Lindfield Learning Village (SSD 8114)
EPA advice on Supplementary Response to Submissions and Amended Proposal

I am writing to you in reply to the invitation to the Environment Protection Authority (EPA) to provide advice on the Supplementary Response to Submission (RtS) and amended proposal to replace the proposed loop road with an internal two-way road.

The EPA reviewed the documents *Response to Submissions Exhibited Phases 2 & 3 of Lindfield Learning Village*, prepared by Urbis dated 16 June 2020 (supplementary RtS), and the *Revised Noise Impact Assessment*, prepared by White Noise Acoustics dated 22 April 2020 (revised NIA), and has ongoing concerns regarding the noise and vibration assessment. In summary these are:

Figure 1 - Aerial view of site and surrounding receivers

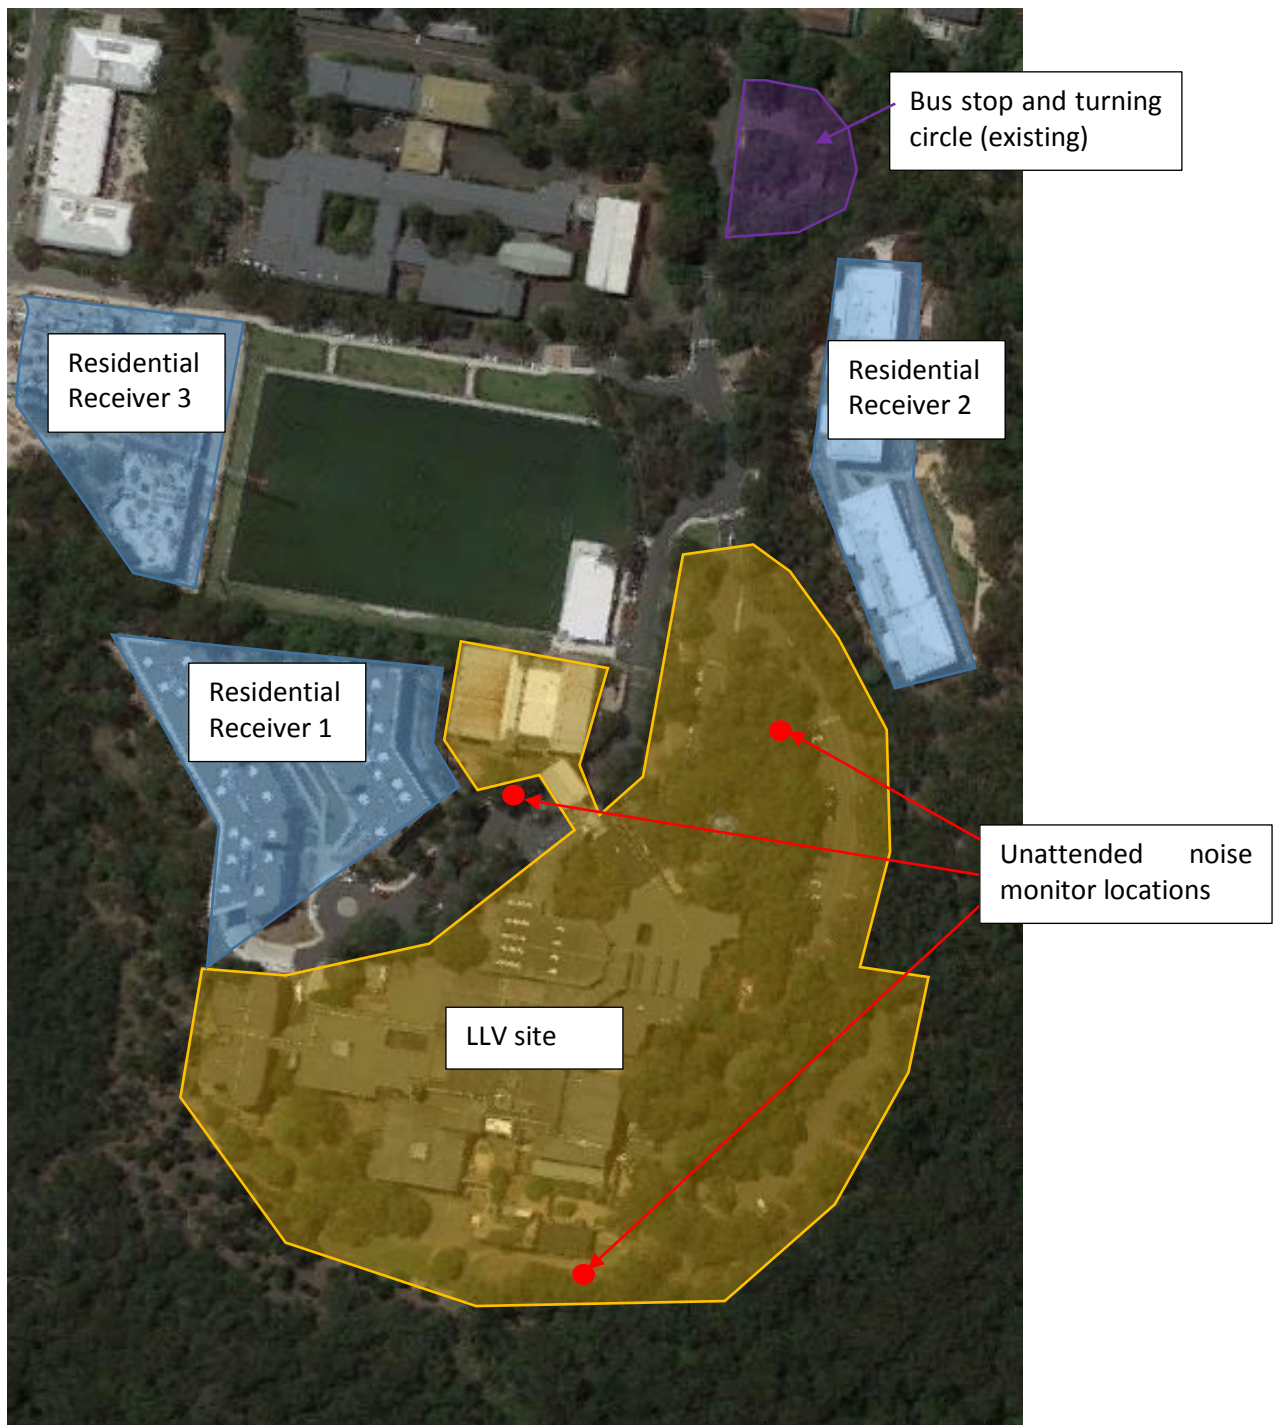
The EPA notes that a quantitative assessment of noise levels from construction has now been included in the revised NIA (Table 16). However, **the mitigation strategy shown within Section 7.4 of the assessment does not contain adequate planning for community consultation and communication**. This is important for this development due to the proximity of the receivers and the likelihood of those receivers being “noise affected” and/or “highly noise affected”.

The revised RtS indicates that the extended driveway option will have positive benefits in terms of increased outdoor play areas. The applicant needs to confirm that the increased outdoor play areas have been considered in the revised noise impact assessment. Further, the revised NIA identifies

that outdoor play area noise goals will be significantly exceeded however no physical mitigation measures are proposed. Any planning determination for this project will need to consider the potential impacts of outdoor play areas and consider these impacts in the project's determination.
